**RE: Guardian Storage
Project #1002132**

The purpose of this letter is to explain the modifications that have been made to the Site Development Plan for Building Permit and Site Development Plan for Subdivision Amendment. The project was approved by the Environmental Planning Commission (EPC) on March 10, 2016.

Condition of Approval – 16EPC-40001 – March 10, 2016 – Zone Map Amendment

Conditions of Approval – 16EPC-40002 – March 10, 2016 – Site Development Plan for Building Permit

Sheet 4 of 6

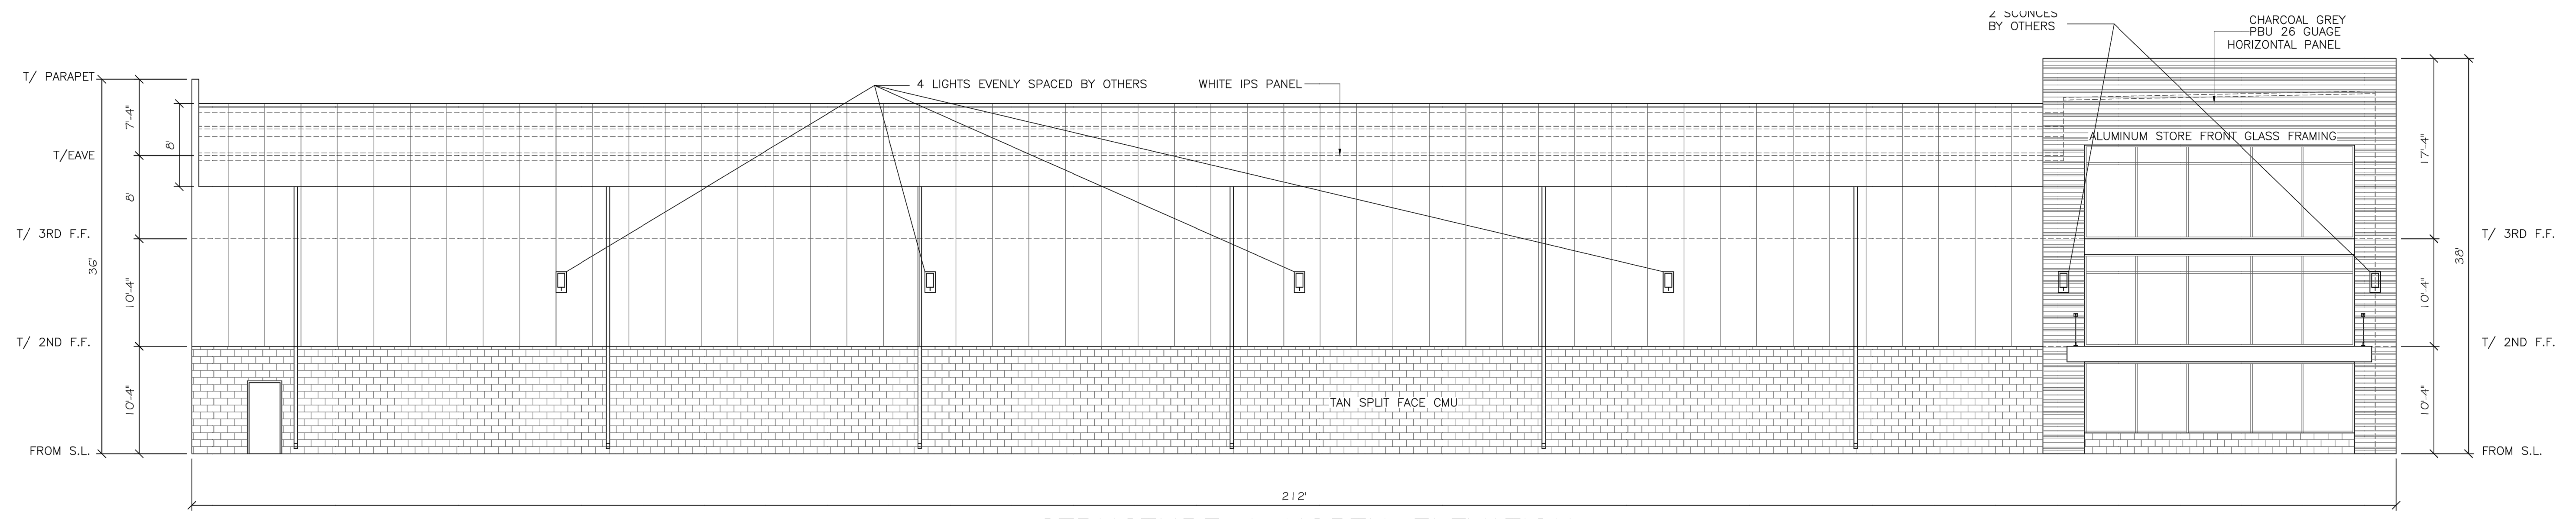
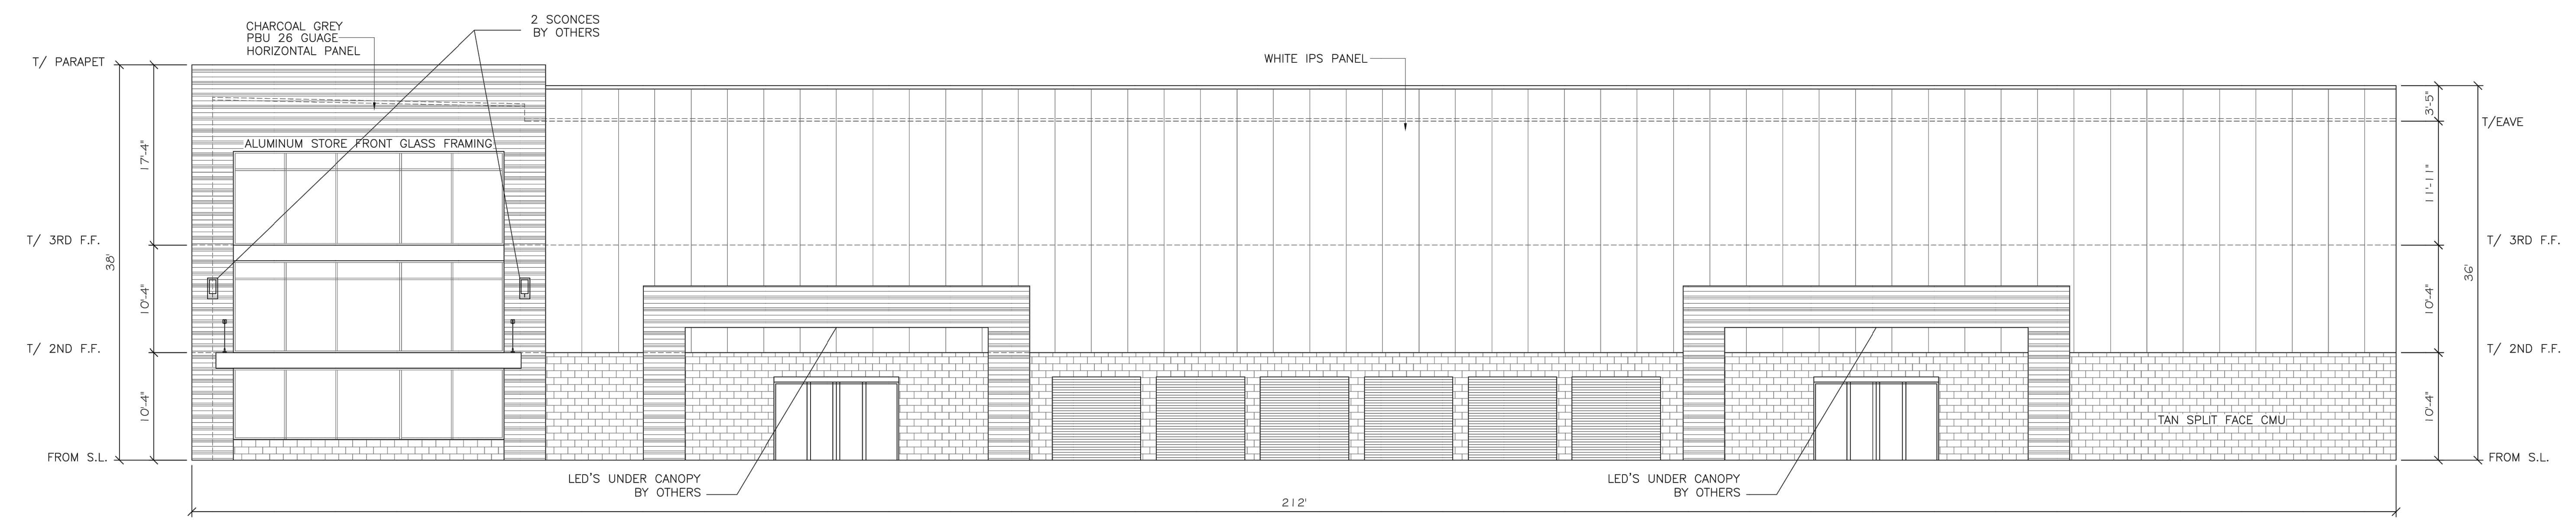
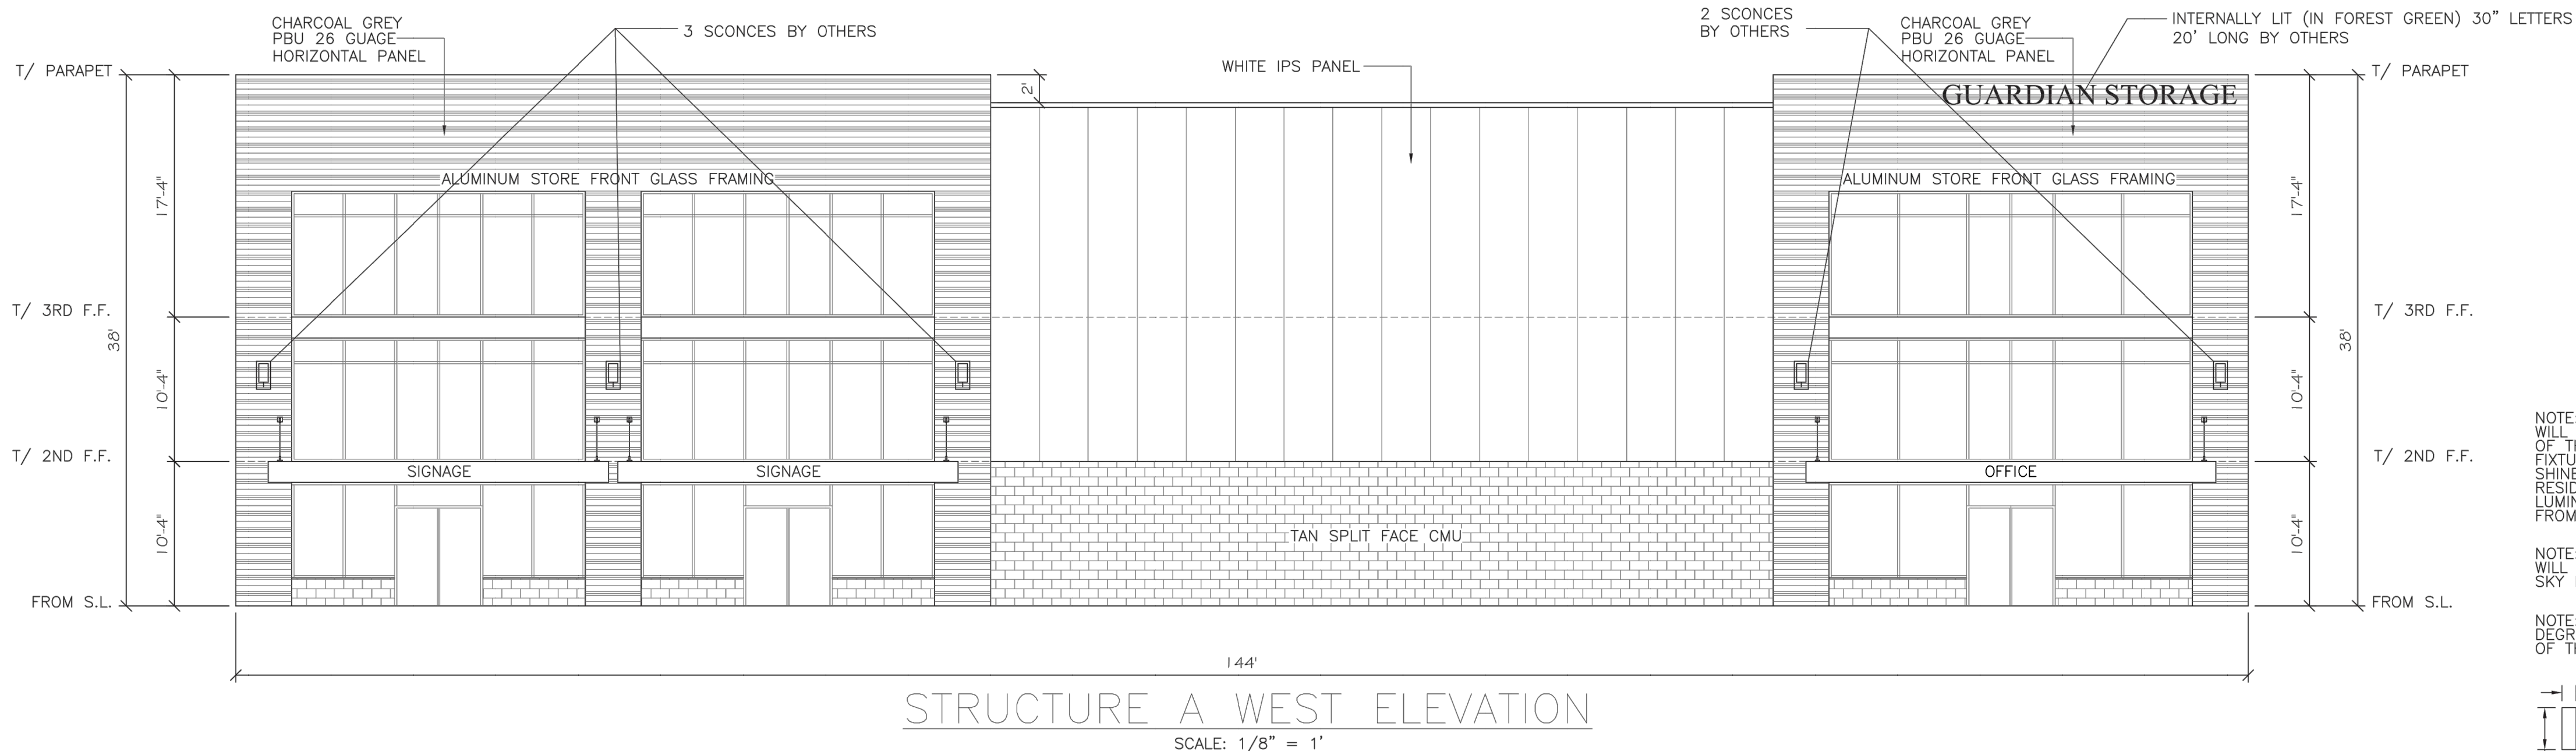
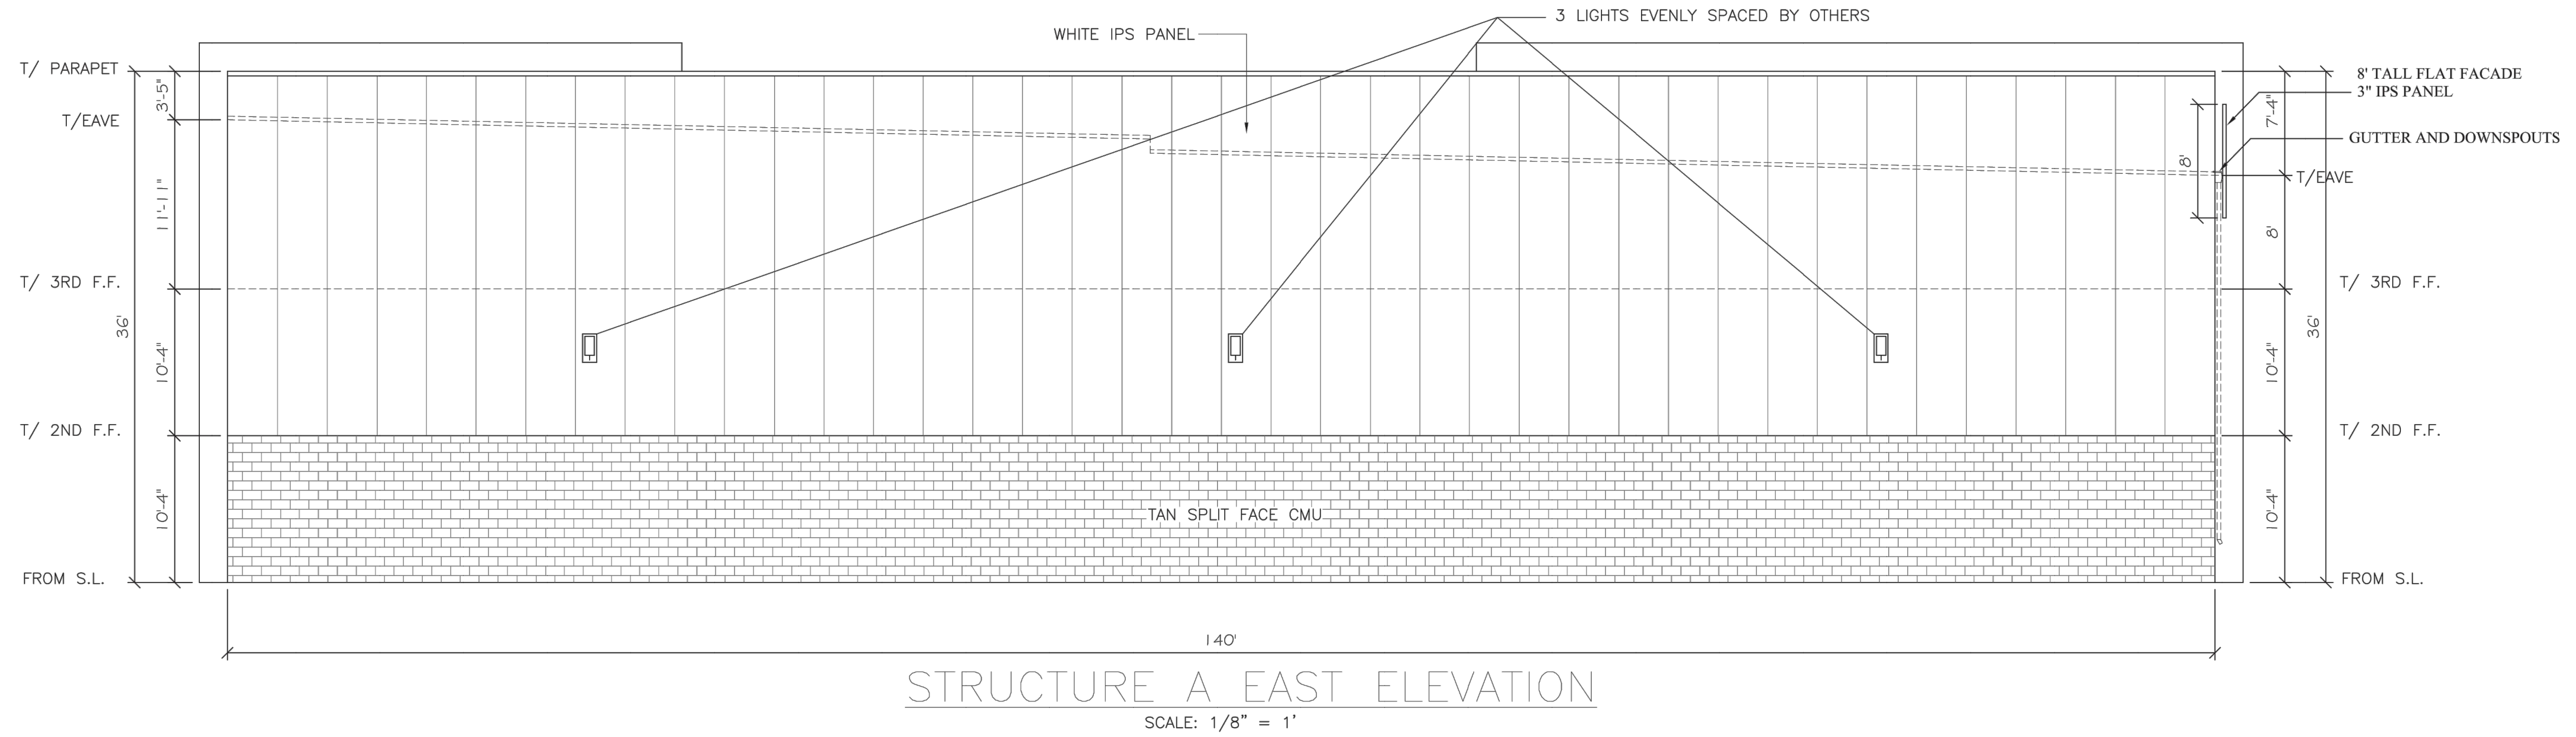
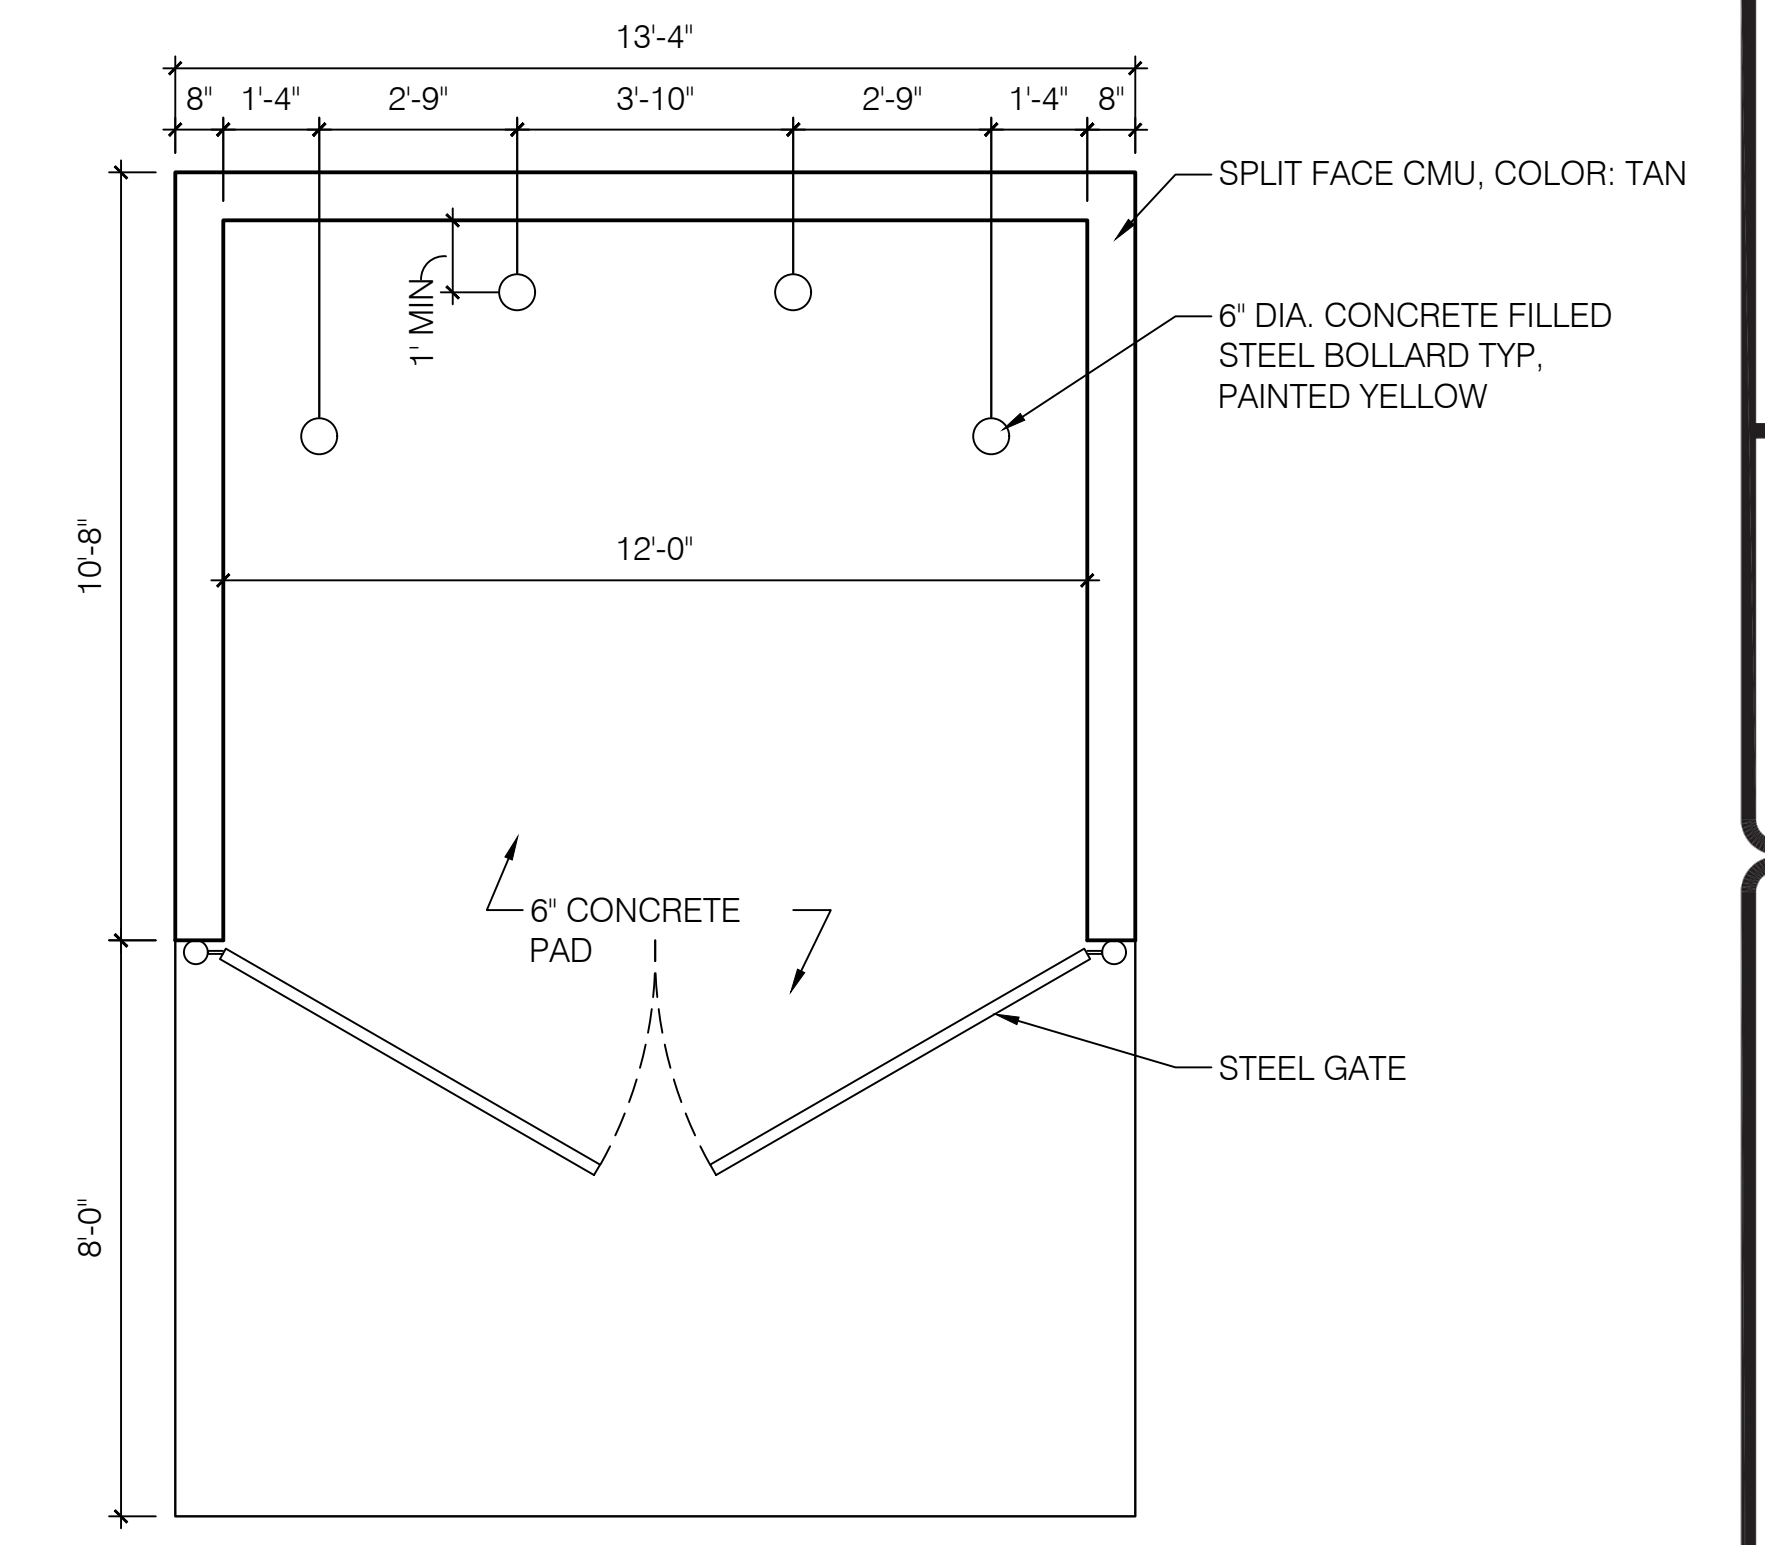
4. The Elevations on Sheet 6 of 6 shall be revised to include notations stating that the lighting plan for the subject site will conform to the Area Lighting Regulations of the Zoning Code 14-16-3-9, and that lighting fixtures must include a cut-off angle, not directly shine on any public right-of-way or any other residential premises and shall not have an off-site luminance greater than 200 foot-lamberts measured from any private property in a residential zone.

6. The Elevations on Sheet 6 of 6 shall be revised to include notations stating that the lighting plan for the subject site will conform to the State of New Mexico Night Sky Protection Act (74-12-1 to 74-12-10 NMSA 1978).

The Elevation sheet has been revised to include this notation.

Agreed.

8. The Elevation Sheet 6 of 6 shall be revised to include a 45 degree angle plane diagram to fulfill the design parameter requirements of the Unser/McMahon Village Center North Site Development Plan for Subdivision because the building is proposed to be taller than 26`.

Our setback is sufficient on all sides to allow the height of the proposed building.
